Harnett County

Permit Number: BCOM2603-0007

Description: 80x100 Multi-Purpose Building at Antioch Baptist Church

LIST OF REVIEWS

1 G2 GROUND FLOOR PLAN- FUTURE UPFIT
 SCALE: 1/8" = 1'-0"

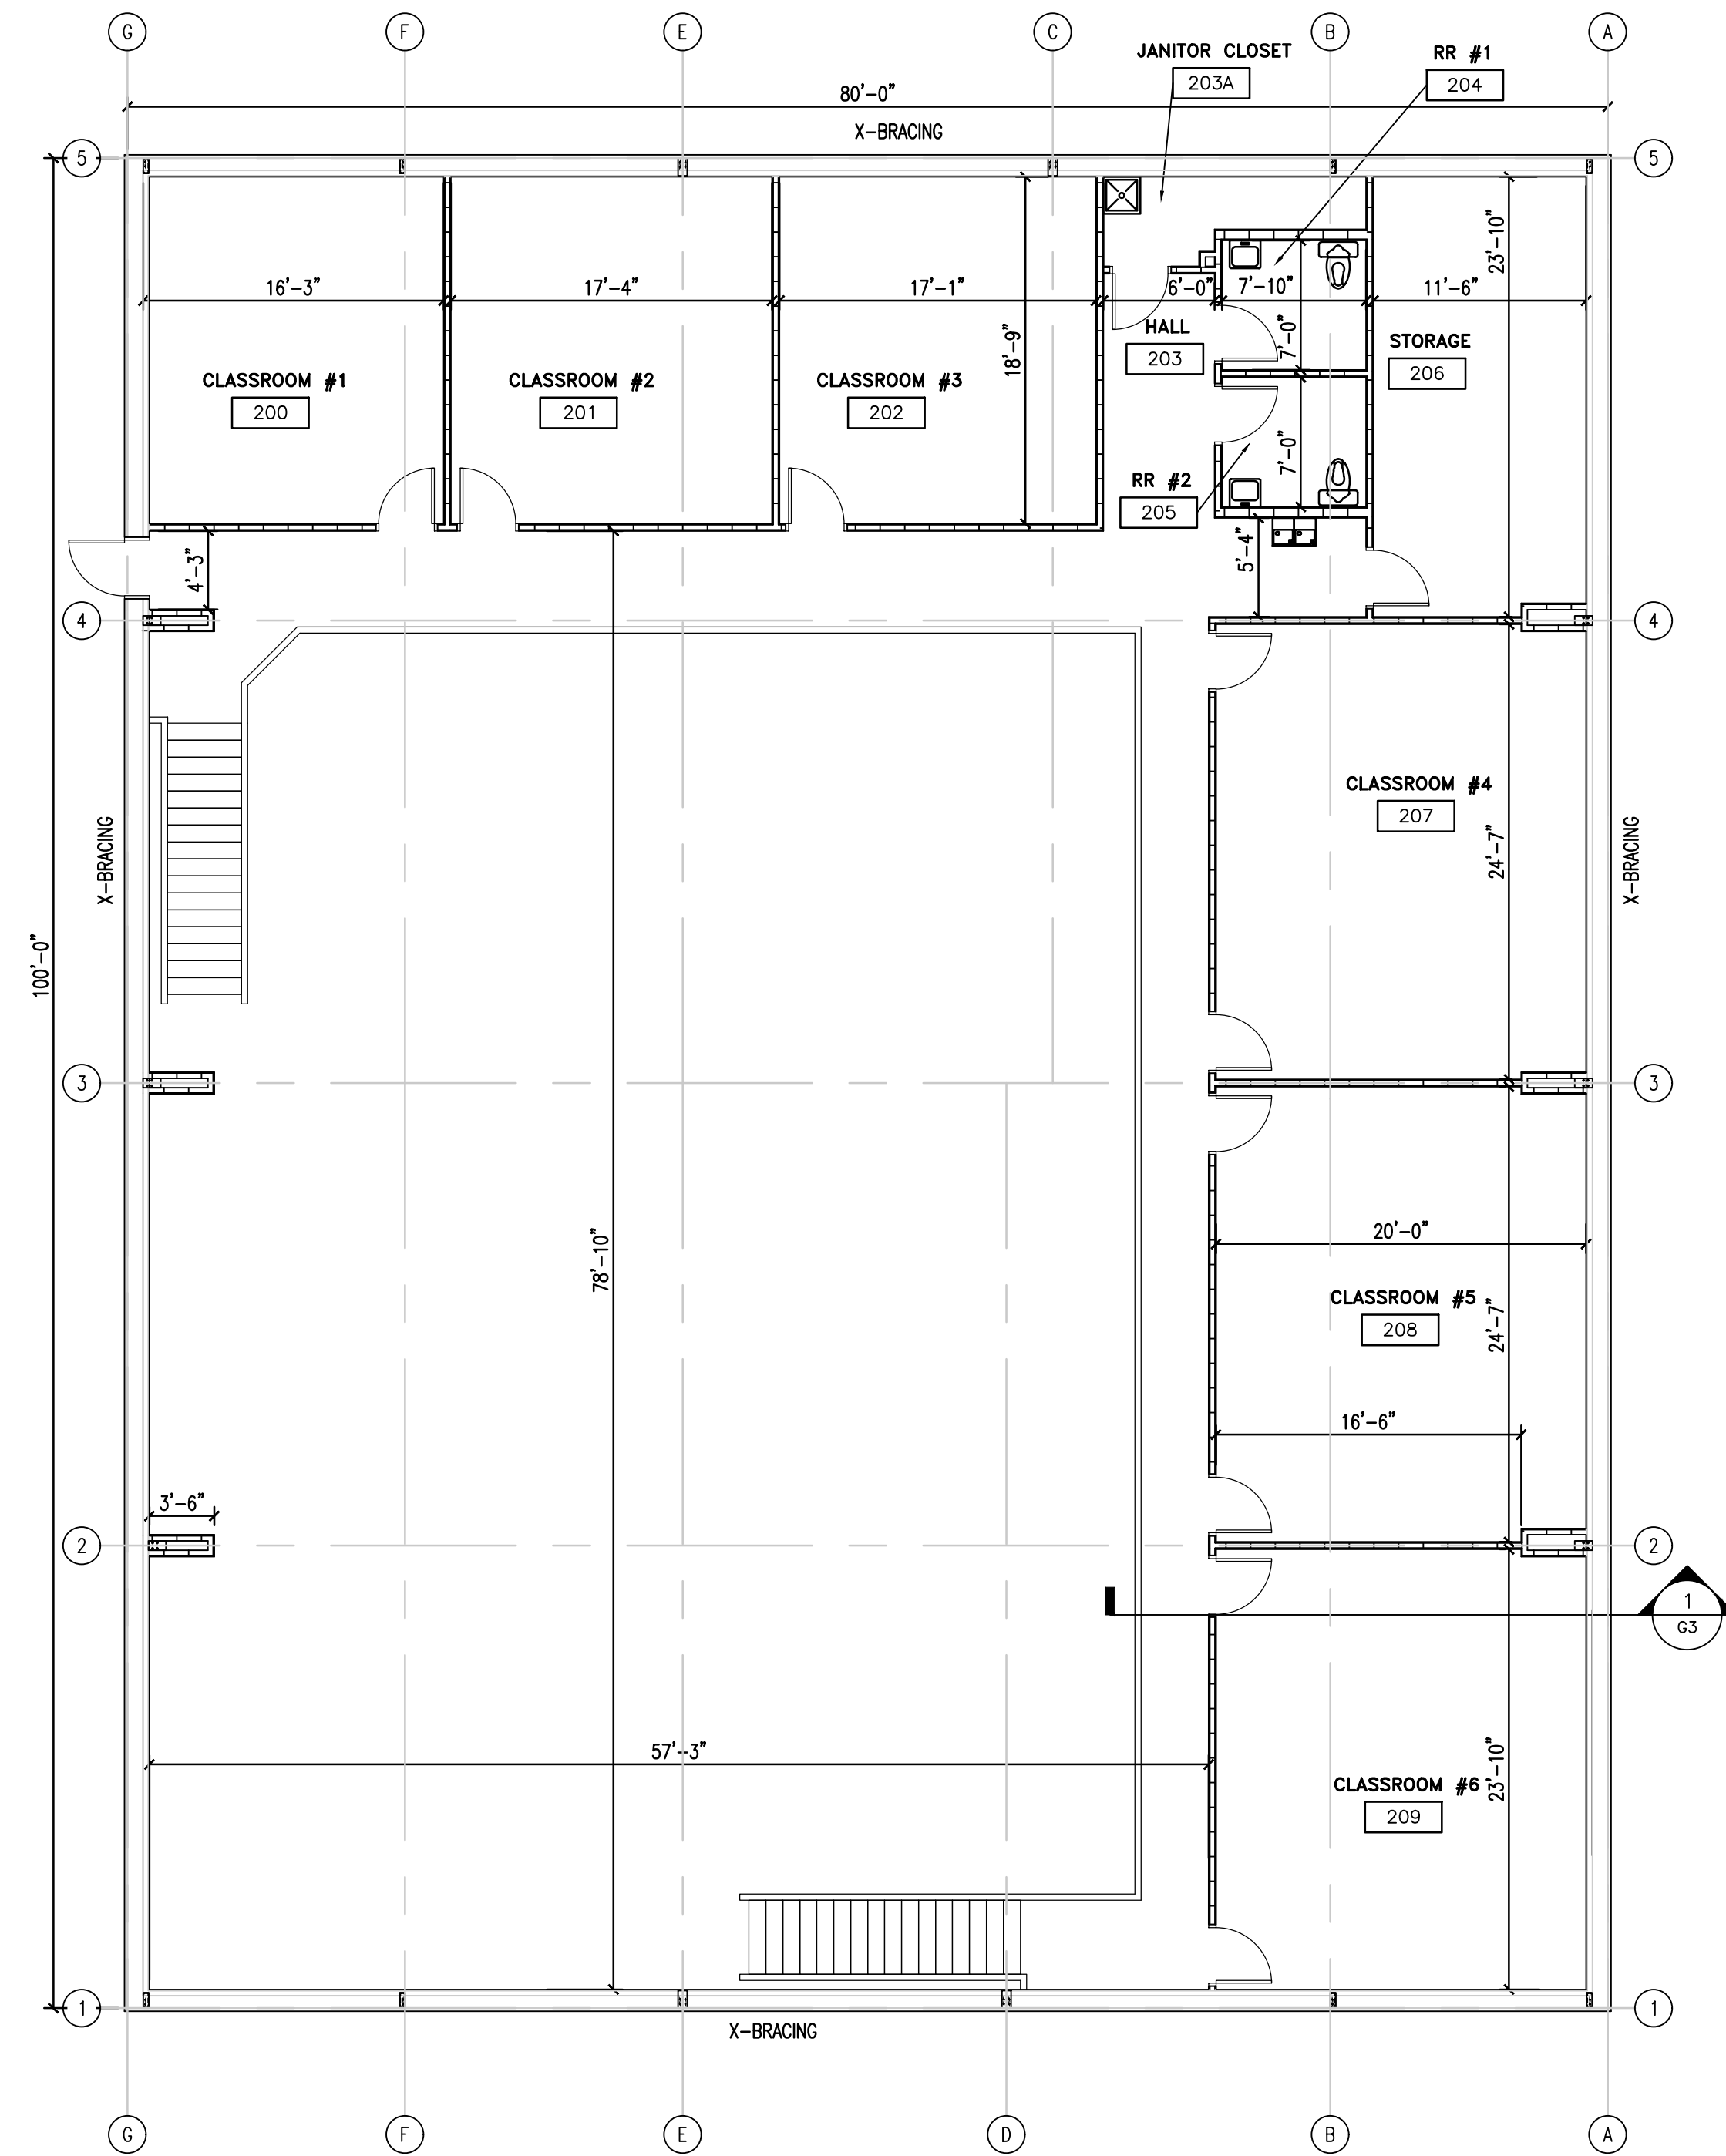
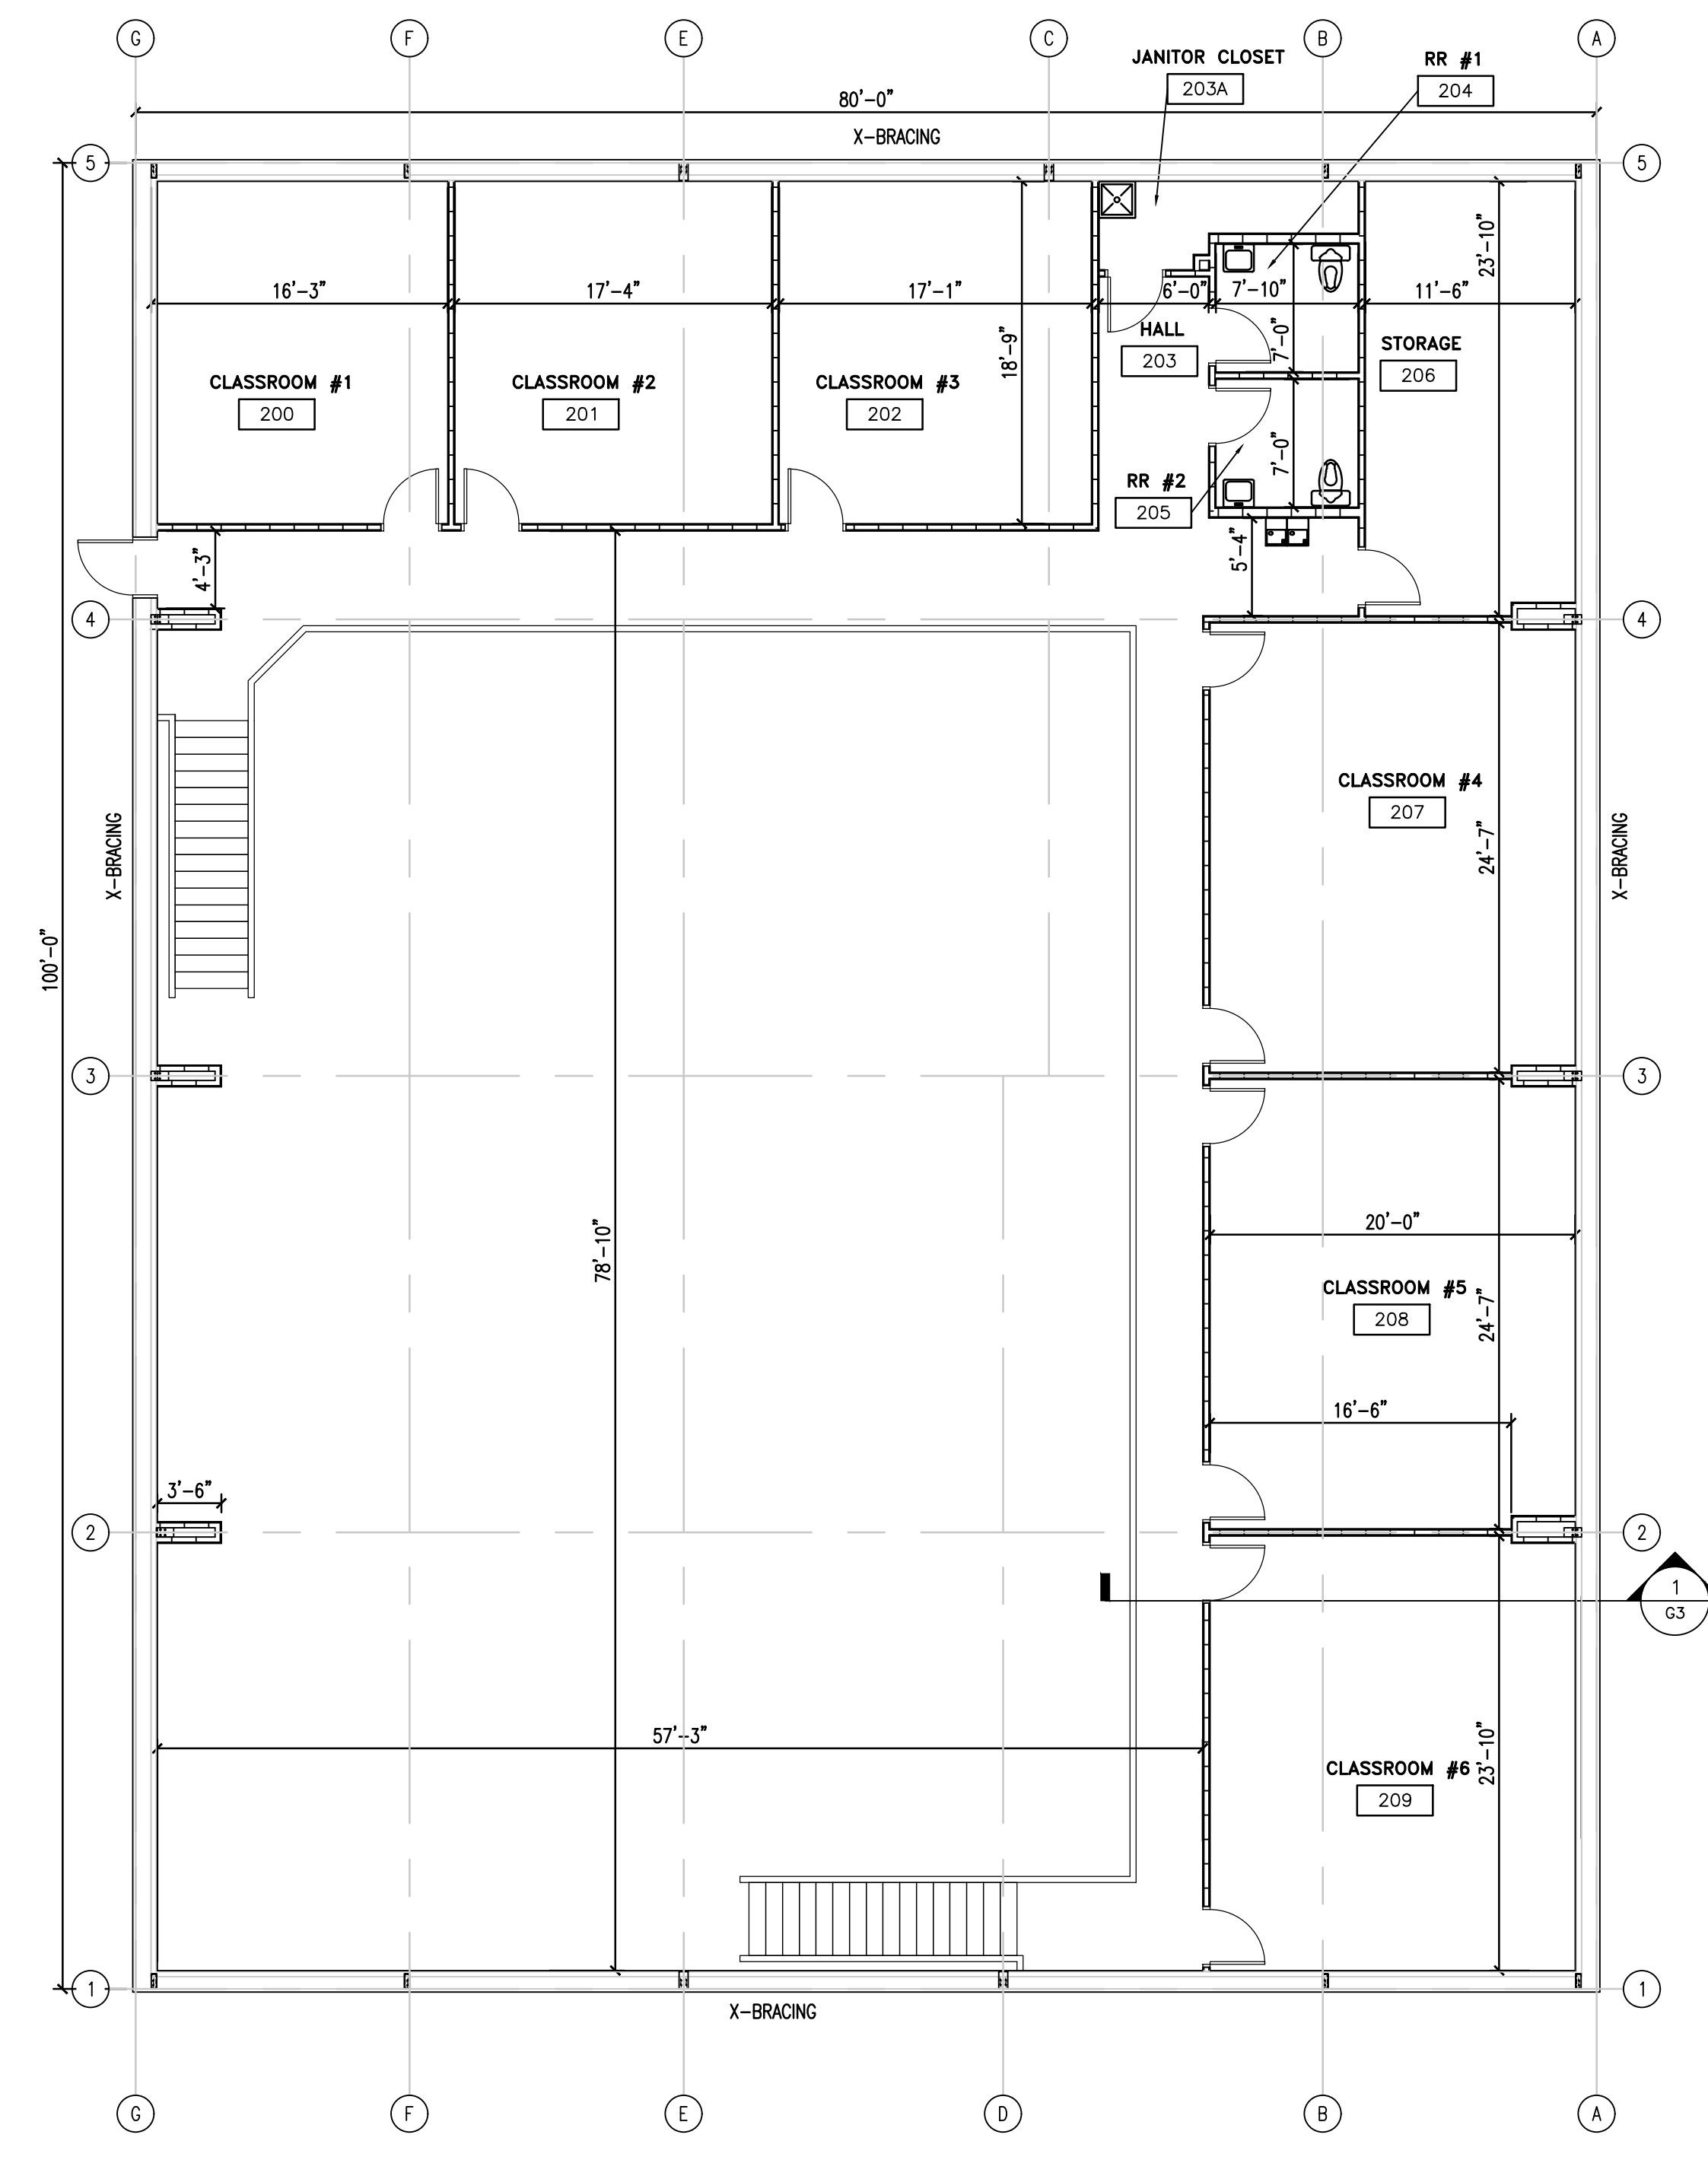
3/25/2026	4/2/2026	4/9/2026	FIRE MARSHAL	Roger Sullivan	DISAPPROVED	See notes
Notes: Need complete set of plans to include life safety plans, architectural and electrical to scale sealed by engineer. Same comments as building inspector.						
5/5/2026	5/18/2026	5/19/2026	COMMERCIAL BUILDING REVIEW	Brad Sutton	APPROVED	
Notes: THIS IS FOR A SHELL ONLY! The attached plan is to be used for plumbing under slab reference only. The upfit plan is currently not code compliant, and may not be used to upfit this shell building
